Rezoning Transportation Analysis

Petition Number: 2021-176

Date	Description
11-19-21	First Review (TM)
12-17-21	Second Review (WB)

CONCEPTUAL REZONING PLAN

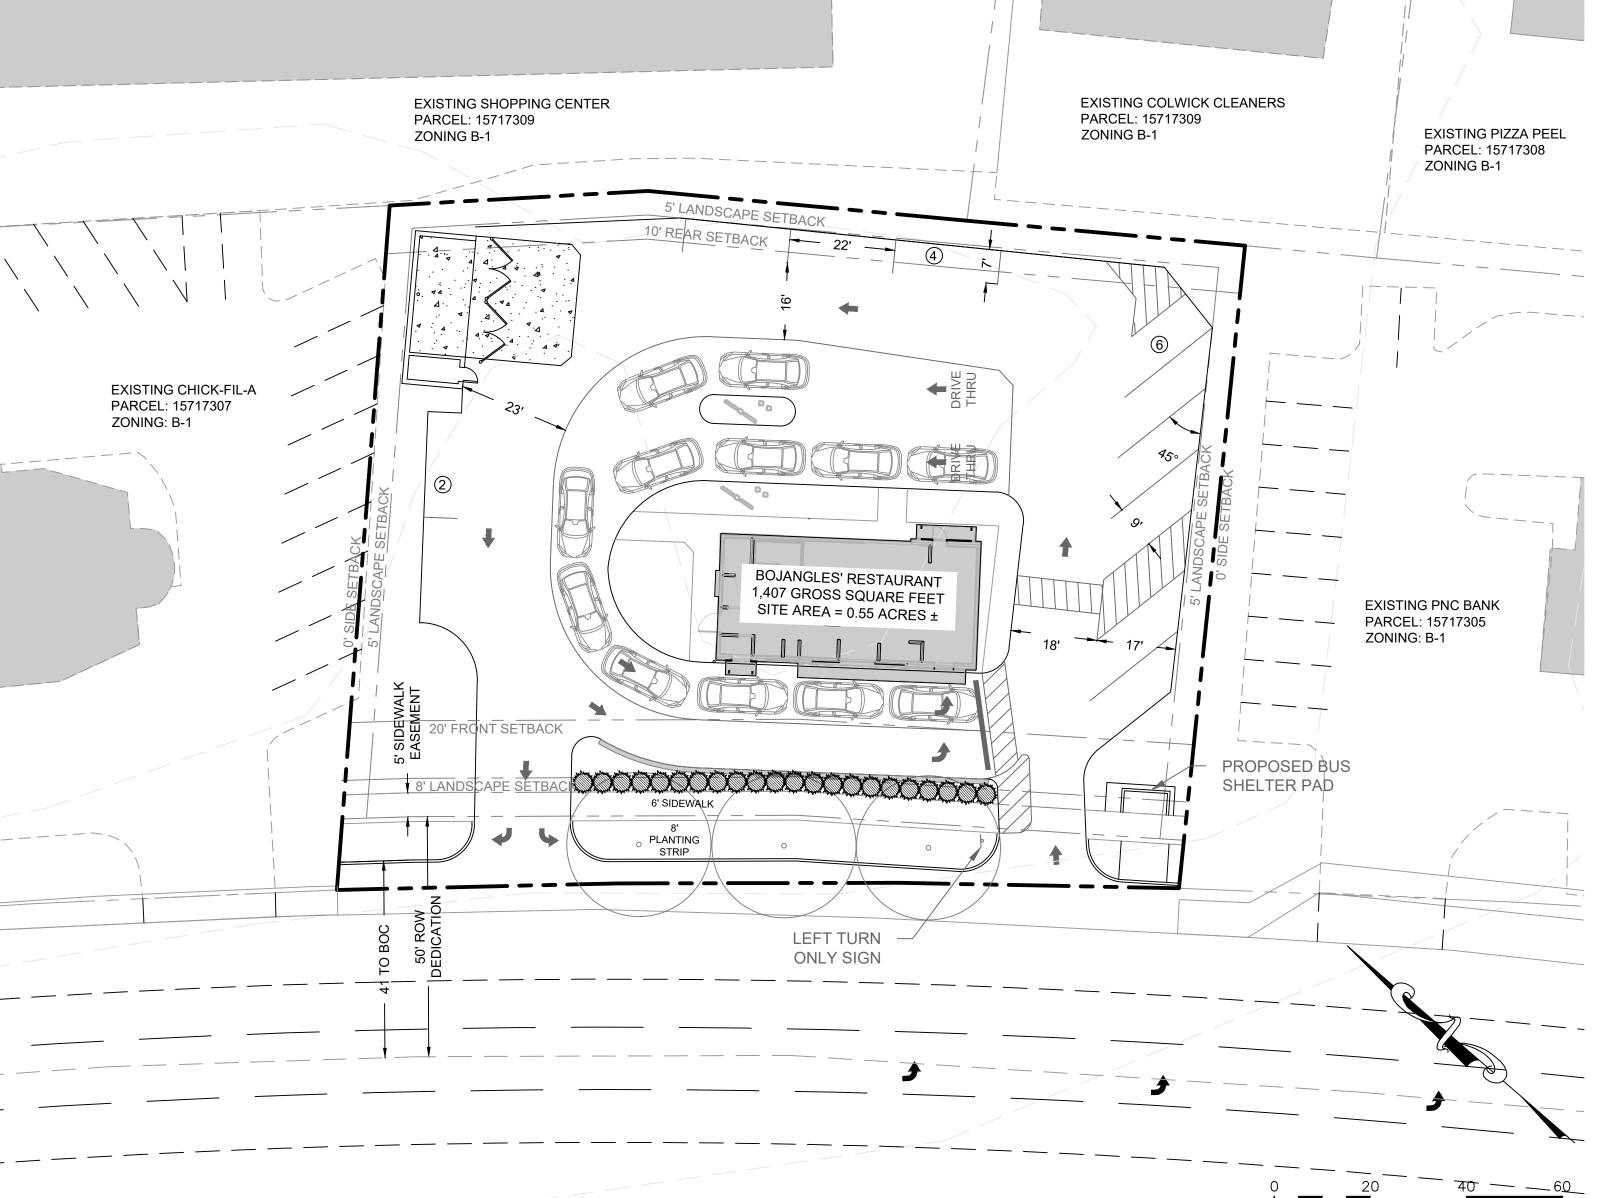
5. COMMENT CLARIFICATION (site plan, 12/15/2021)

Revise site plan and condition note(s) to commit to maintaining a consistent offset from the back of curb to the sidewalk along the site's frontage. Developer to transition to the adjacent sidewalk at the property line using CLDSM 10.23 or at the property line with an interim perpendicular tie in. Refer to markups below.
